From: Rich Elliott <elliotttr@kvfr.org>
Sent: Wednesday, March 11, 2015 9:45 AM
To: Lindsey Ozbolt
Cc: Joe Seemiller; John Sinclair; Josh Hink; Brenda Larsen
Subject: RE: CU-14-00006 WDFW Hwy 10 CUP - Notice of Application

WDFW Hwy 10 CU-14-00006 & SD-14-00003

Kittitas County has received the above referenced land use applications know as the WDFW Hwy 10 Conditional Use Permit and Shoreline Conditional Use Permit. The request is for a new boat launch and haul-out area along with up to 12 parking spaces and a portable toilet facility on a 3.19 acre parcel that is zoned Agriculture-20 and has a Shoreline designation of Conservancy.

NEW SITE PLAN

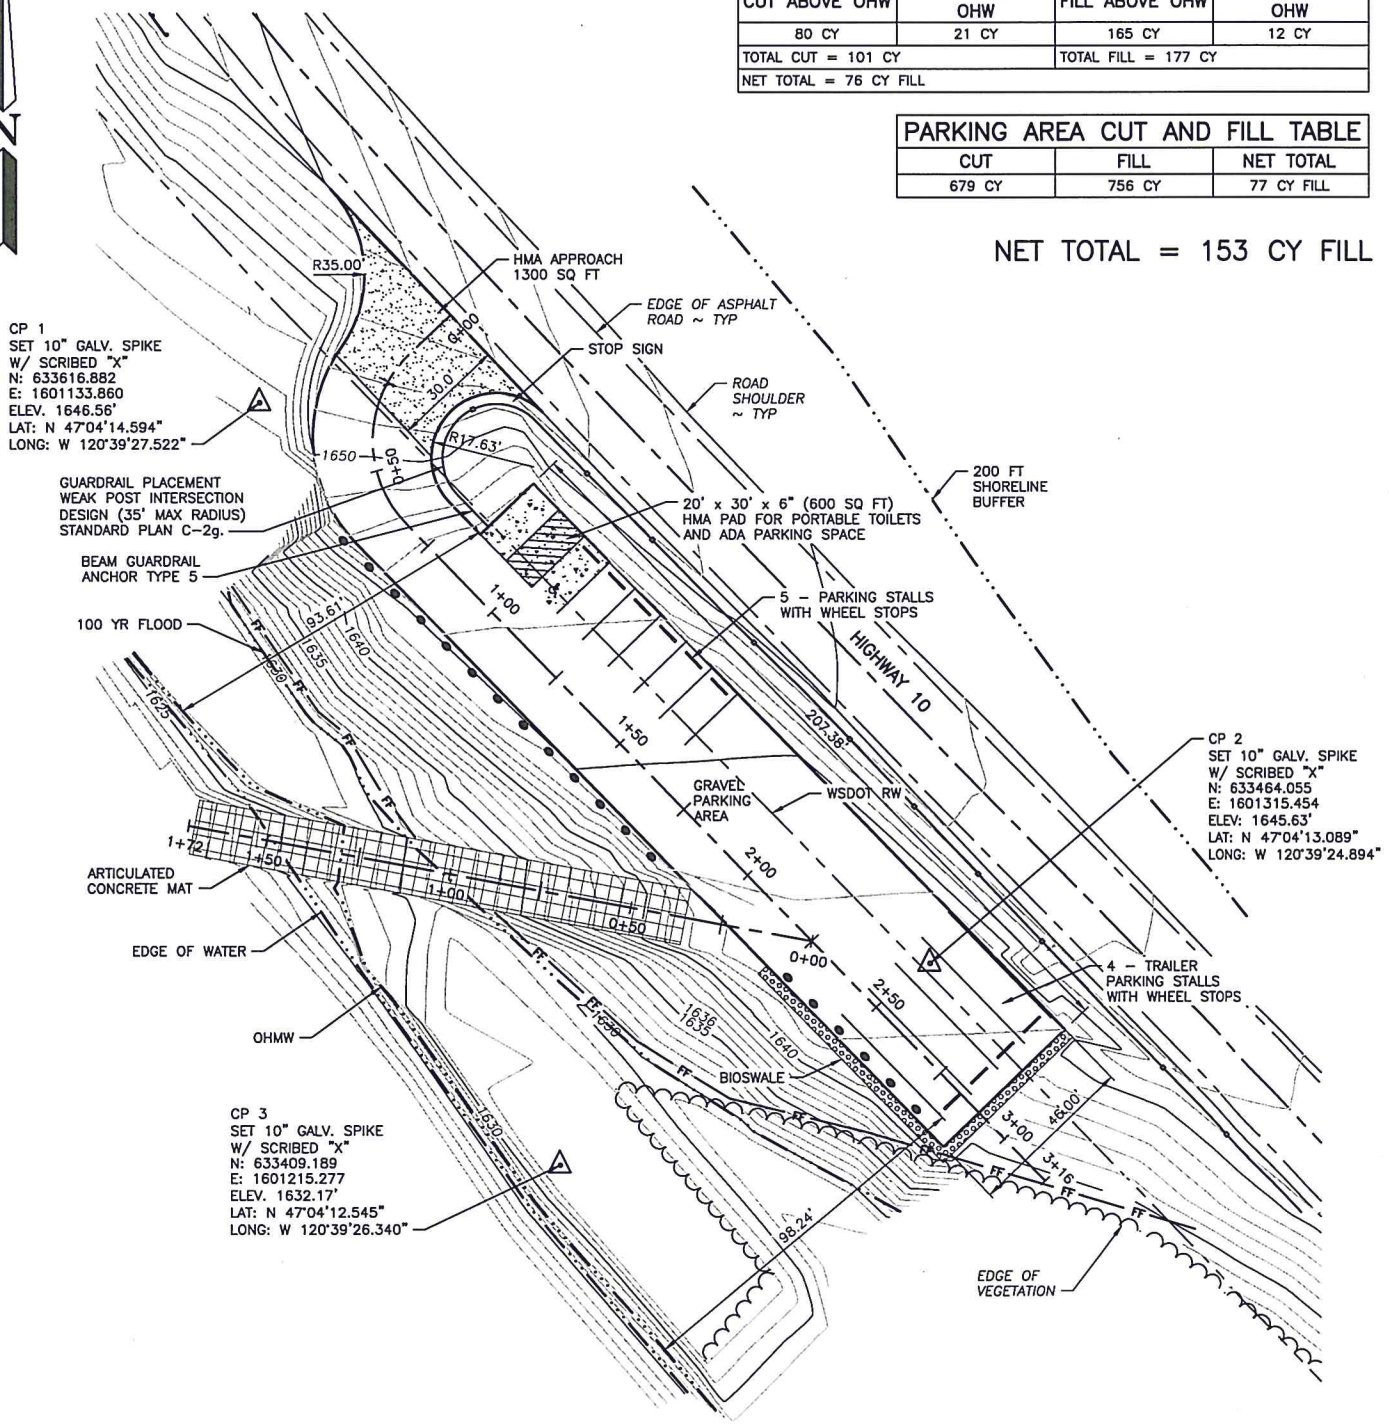
KVFR requests that the access be IFC compliant and that the address be clearly visible from both directions.
